BEACON FEN ENERGY PARK

PROPOSED BEACON FEN ENERGY PARK (APPLICATION REFERENCE: EN010151)

REQUEST FOR PROPOSED CHANGE TO THE DCO APPLICATION ('CHANGE REQUEST')

FIGURE 6.31  
LANDSCAPE STRATEGY PLAN  
CABLE ROUTE CORRIDOR (Sheet 1 of 2)

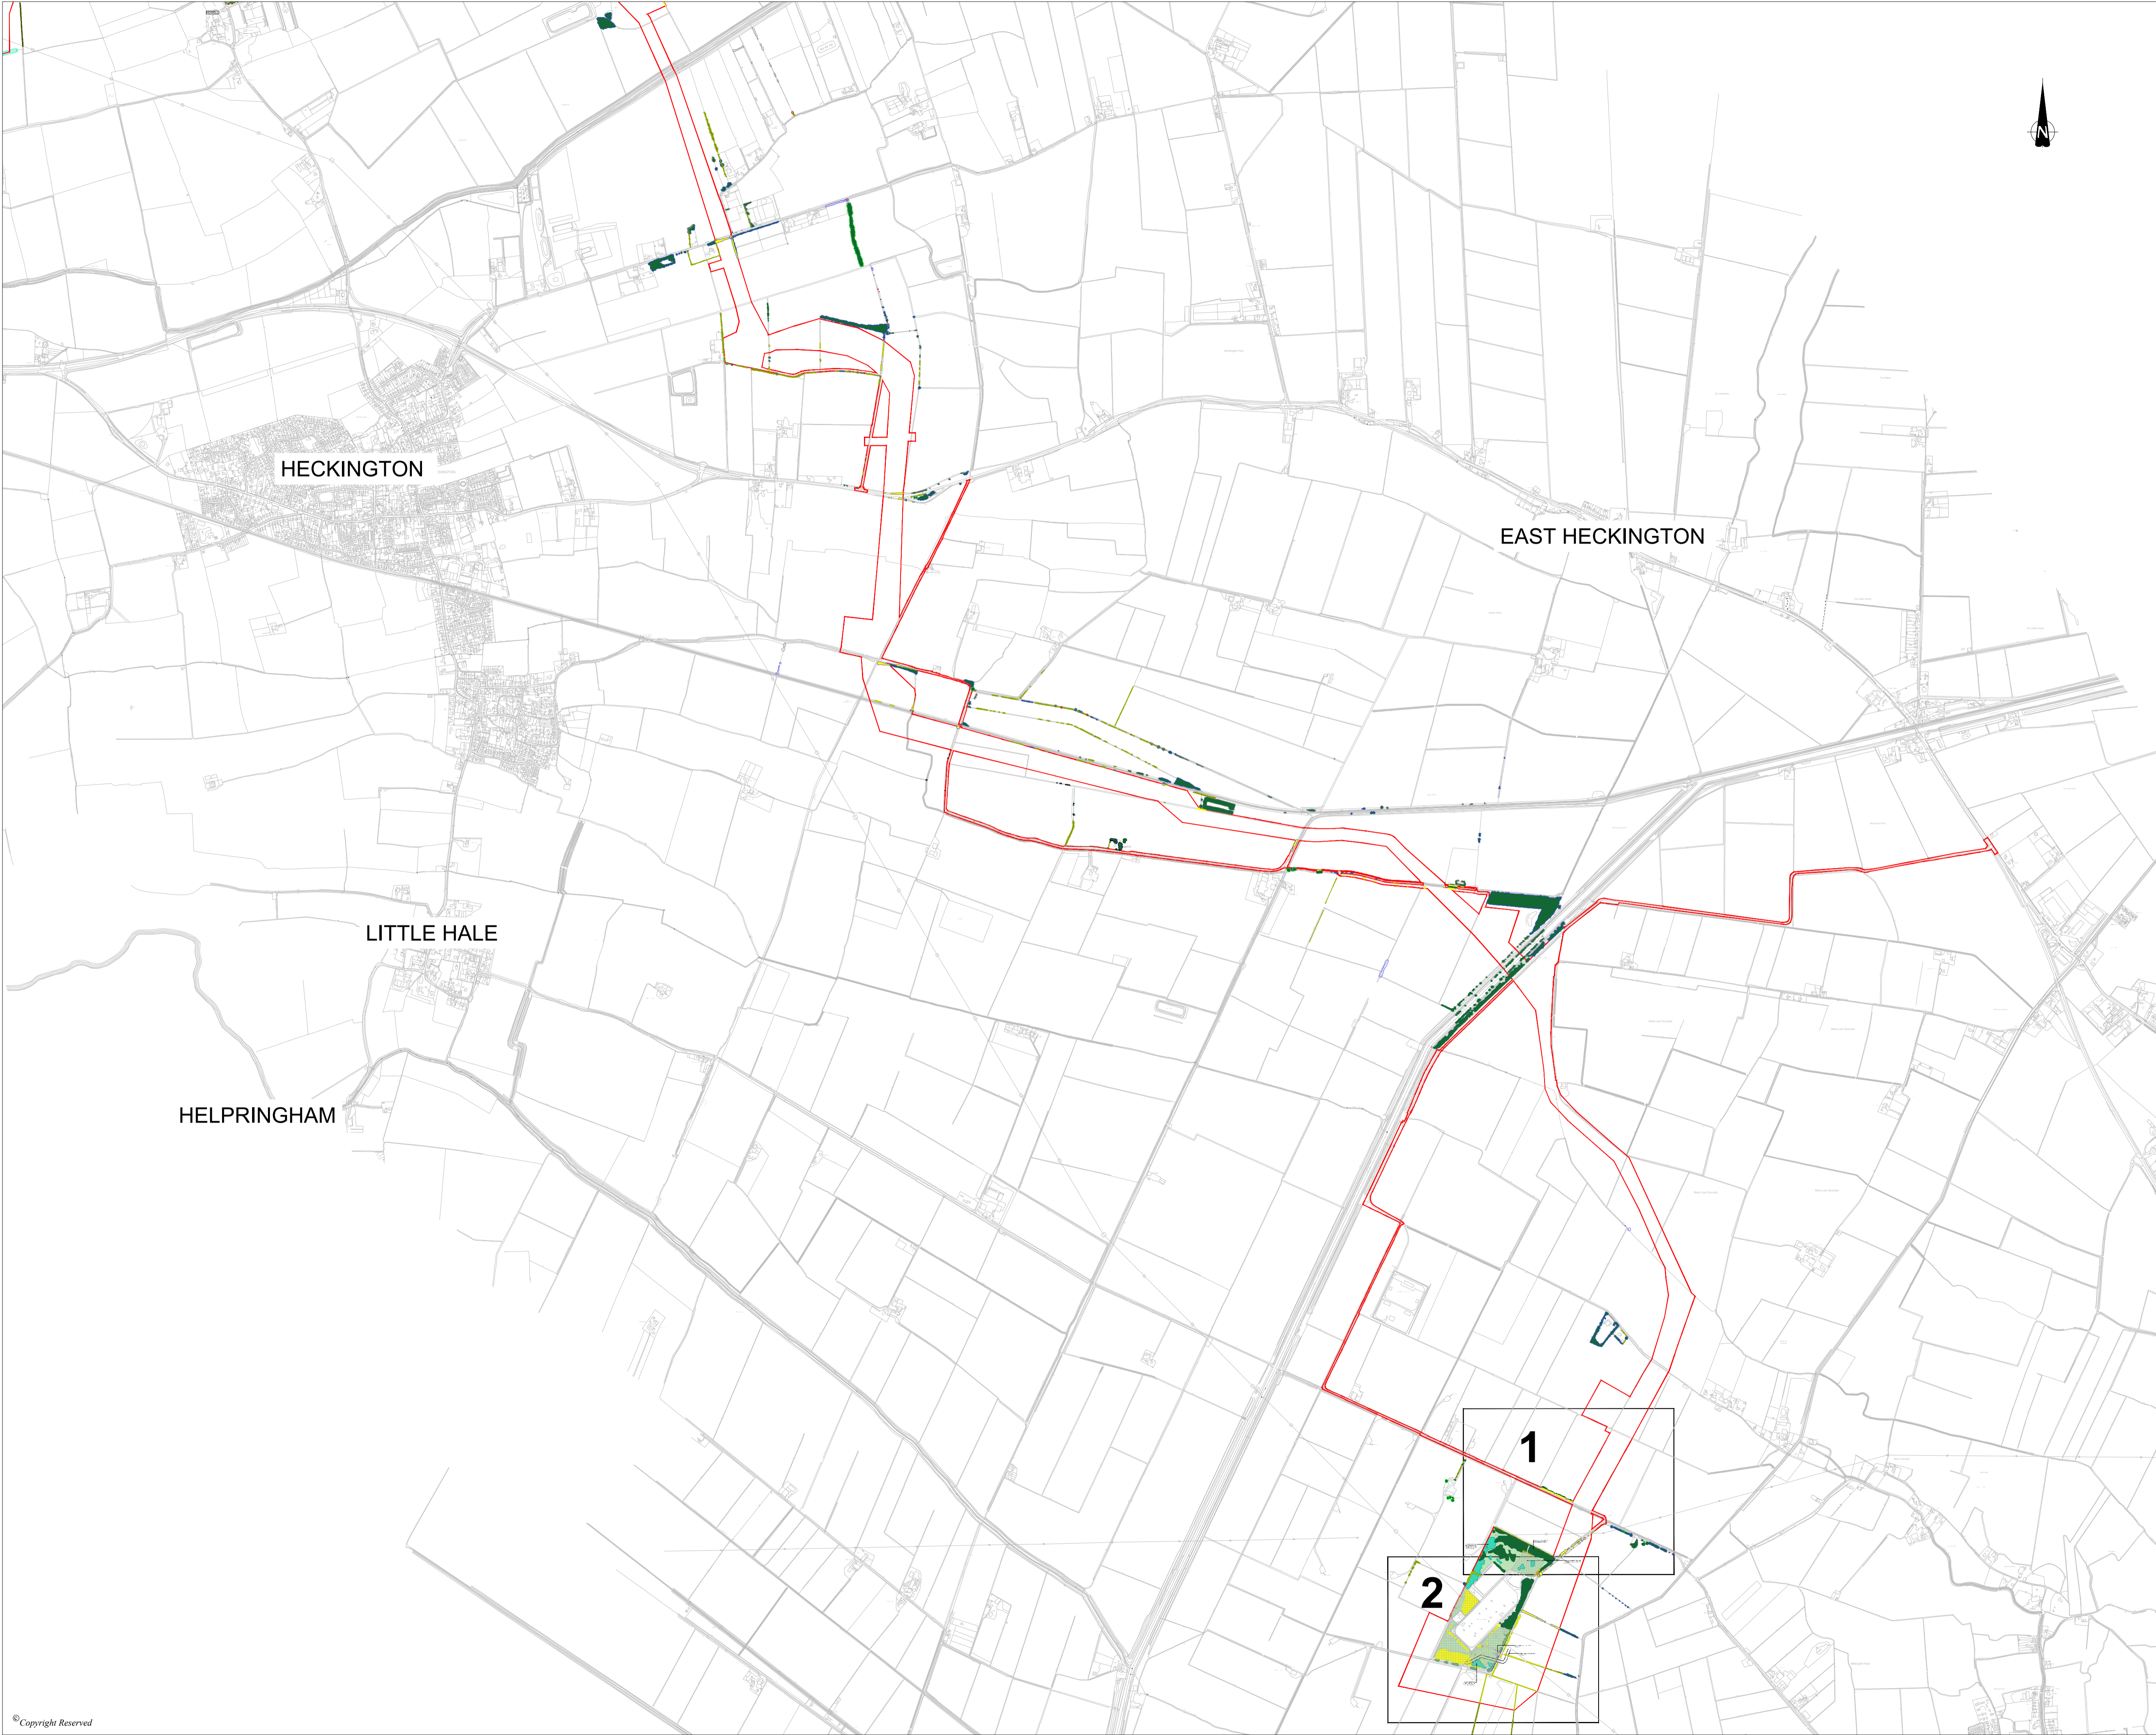
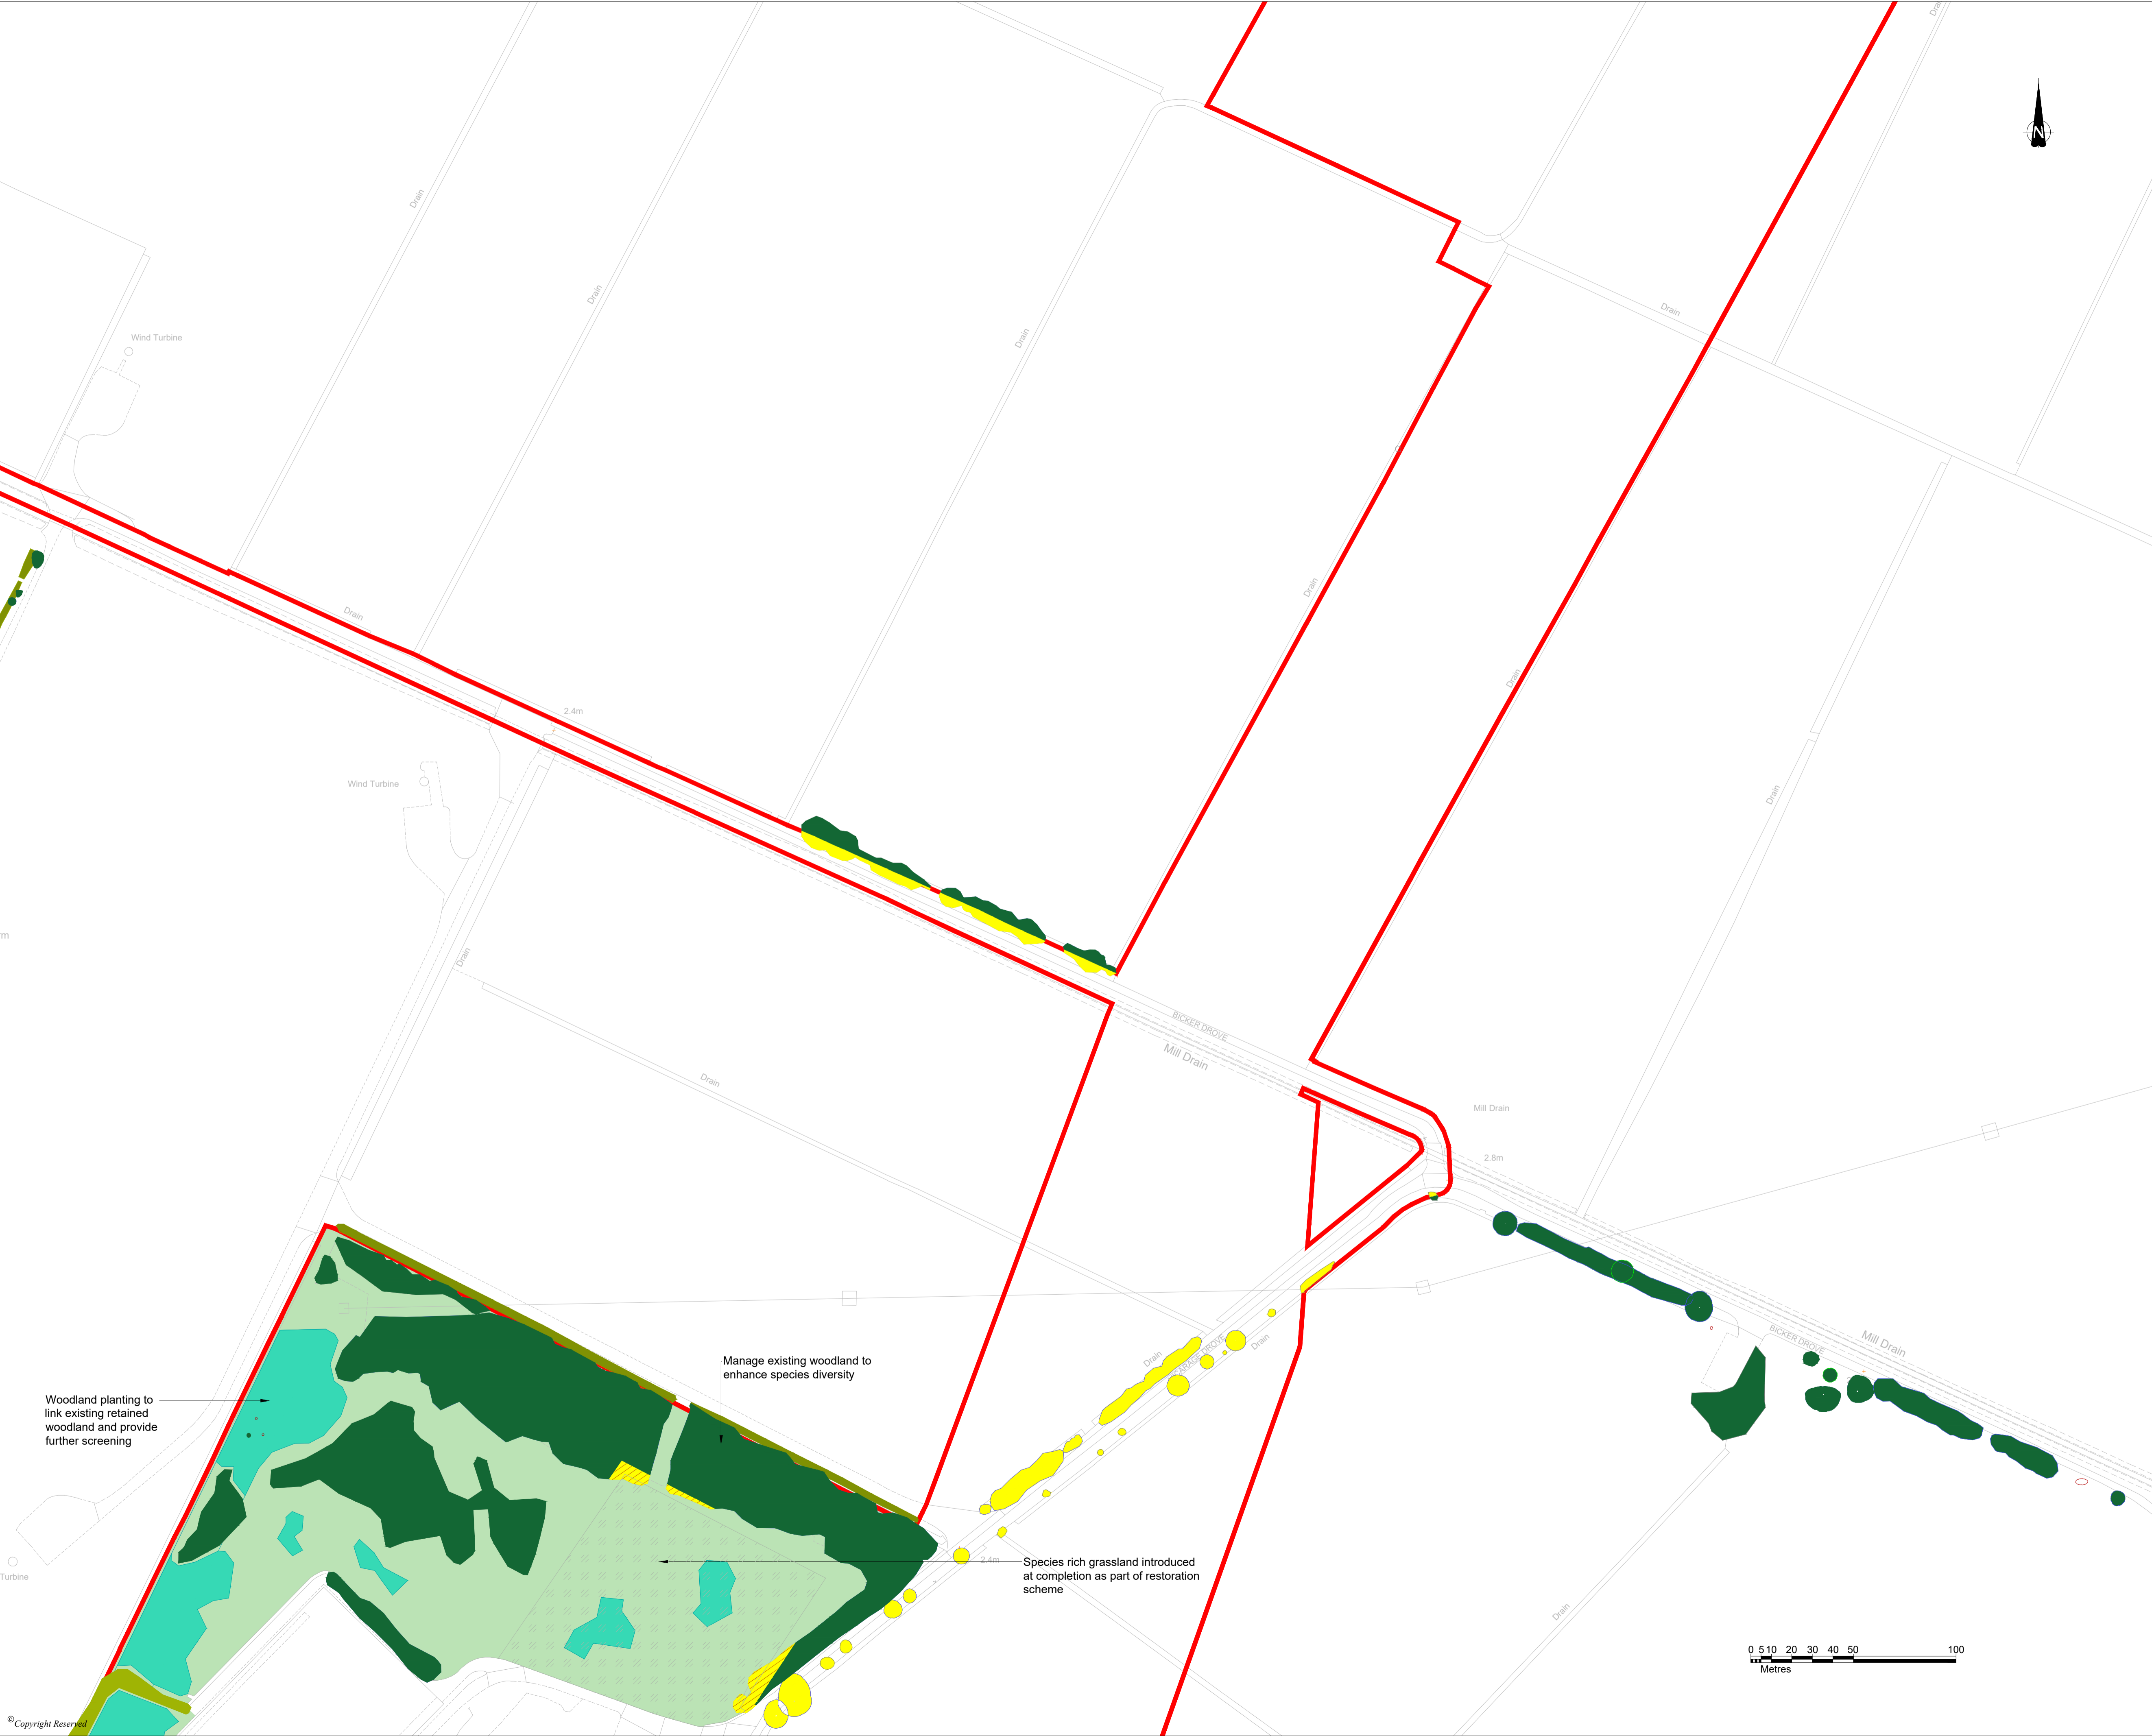
The Change Request reflects an updated design provided by National Grid Electricity Transmission plc (NGET) to the Applicant for the proposed extension to Bicker Fen Substation (the 'Substation'), which has been provided following continued engagement between the parties. The design change is reflective of NGET's latest proposed design, which has evolved as NGET has progressed through its

- Construction of one new access in the form of a new bell mouth adjoining Vicarage Drove to the south-east or south of the Substation for access the extension and pylon/tower. The new access would be located within the existing extent of Work No. 10;

- Extension of the temporary laydown (Work No. 5D) to an area that is largely existing hardstanding adjacent to the south; and
- Vegetation removal and infilling of the existing drainage pond adjacent the Substation to construct the Substation extension works (Work No. 5E);
